# DRB CASE ACTION LOG (Preliminary/Final)

DRB Application No.: 11DRB-70108 Project # 1008268  
Project Name: CACU  
Agent: TERRAMETRICS of New Mexico Phone No.:

Subdivision Name: CACY BLOCK E LOT 7A

**PLAT OF
 LOT 7-A, BLOCK E
 CACY SUBDIVISION
 SITUATE WITHIN
 PROJECTED SECTION 2
 T.10N., R.3E., N.M.P.M.
 TOWN OF ATRISCO LAND GRANT
 CITY OF ALBUQUERQUE
 BERNALILLO COUNTY, NEW MEXICO
 MAY 2011**

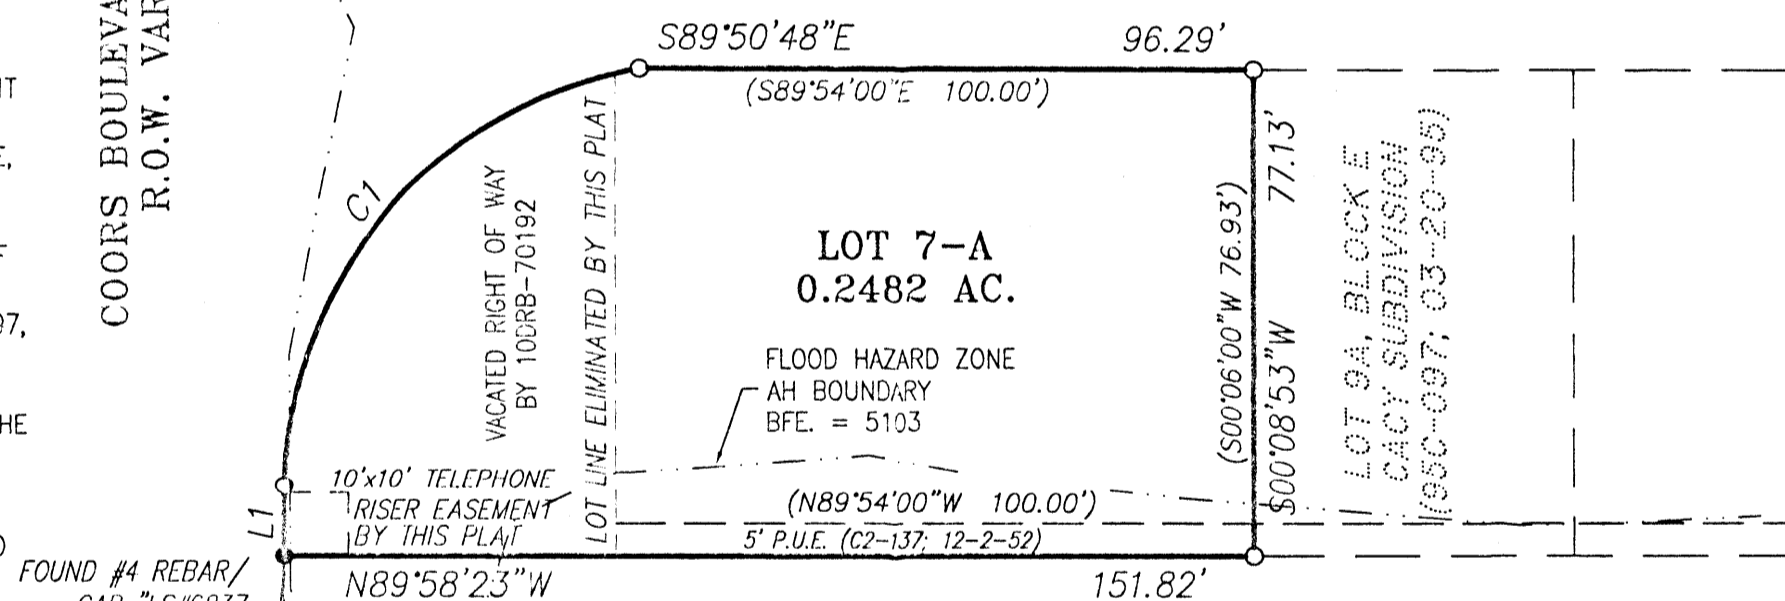
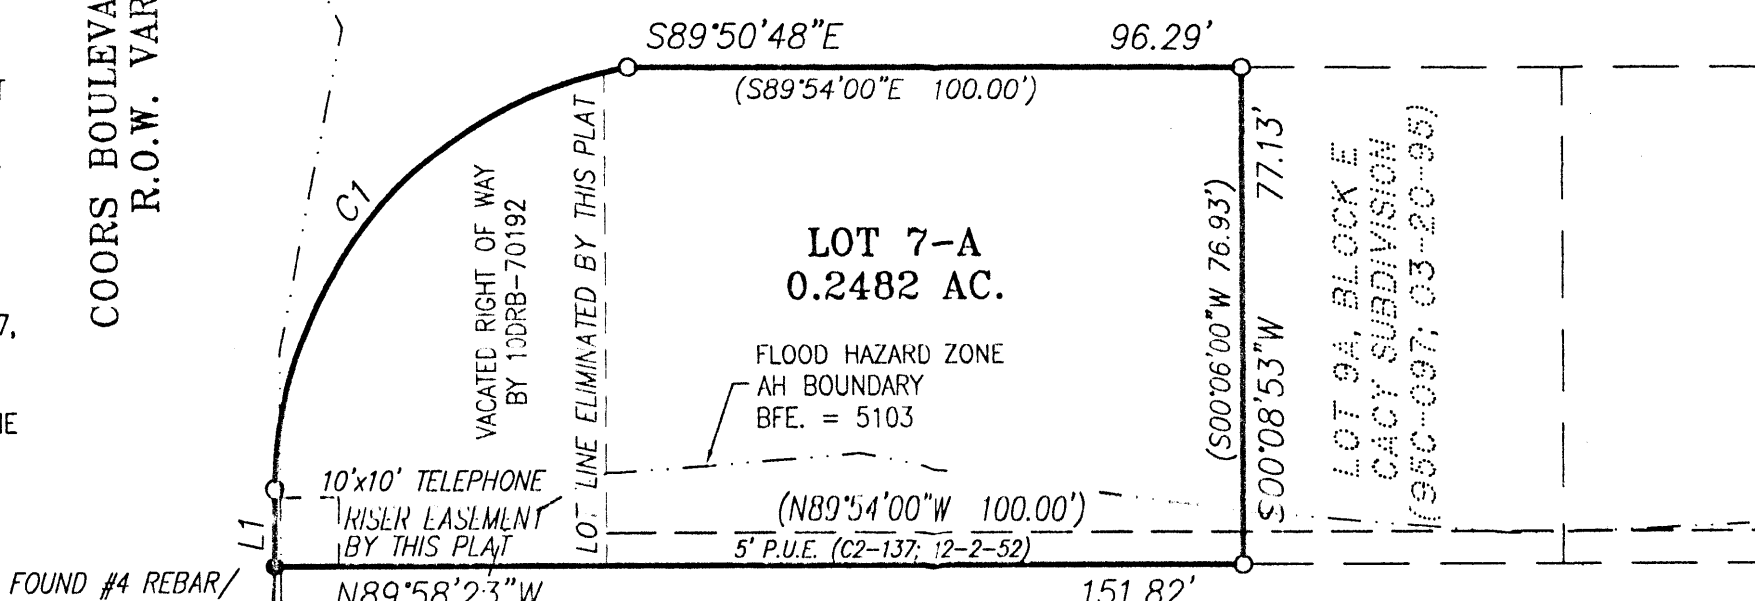
CITY ENGINEER / AMAFCA: - show special Flood Hazard Zone
